From: Amanda Scholes on behalf of Planning.Responses
Sent: 12 January 2022 08:00
To: Planning Scanning
Subject: FW: Planning Consultation on: AL/141/21/RES

Engineers Comments Regarding Surface Water Drainage

Application No: AL/141/21/RES
Registered: 20th December 2021
Site Address: Land North of Lee's Yard Lidsey Road Woodgate PO20 3SU
Grid Reference: 493870 104003
Description of Works: Approval of reserved matters following outline planning permission AL/21/20/OUT for the approval of the appearance, layout, scale and landscaping for 5 No 4-bed dwellings, 14 No 3-bed dwellings & 19 No 2-bed dwellings. This site is in CIL Zone 3 and is CIL Liable as new dwellings.

Protection Plan

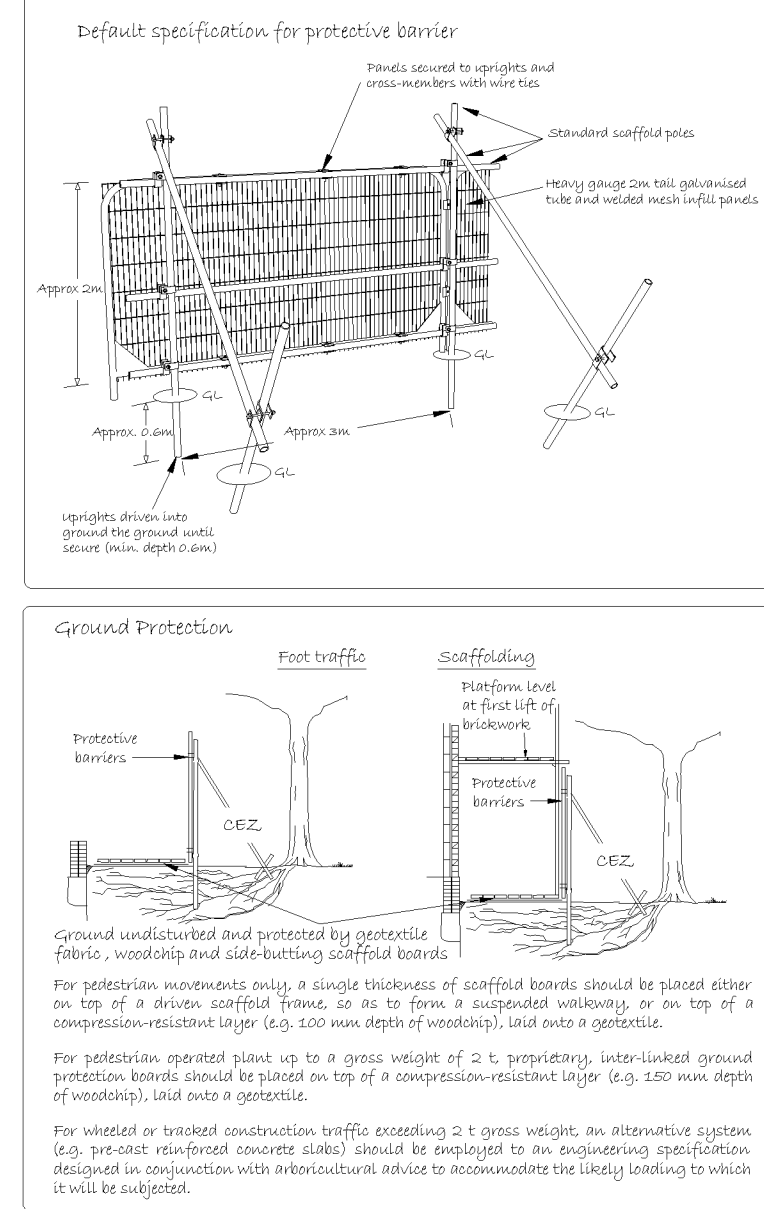
The proposed attenuation basin is proposed within very close proximity of the watercourse. The basin must be located a minimum of 3m from ordinary watercourse. The location of existing trees should also be carefully considered with basin design. The basin is proposed to be bunded above surrounding ground level, this will result in

water being held above surrounding ground level. Water should be retained below existing ground level as much as possible to remove the risk of breach.

1. Please adjust the basin position to ensure a minimum of 3m between the top of bank of watercourse and toe of retaining bund.
2. Please adjust the basin position to ensure a minimum of 3m between the toe of bund of the detention basin and existing tree root areas.
3. Please adjust the basin size to ensure that 300mm of freeboard is provided above peak anticipated water level.
4. Please adjust the basin so that it is set lower in the ground.
5. Please supply details of the improvements that will be completed to the ordinary watercourse.
6. Flotation calculations should be supplied to evidence that it will be possible to deliver the basin as proposed and that design will adequately consider the risk of floatation.
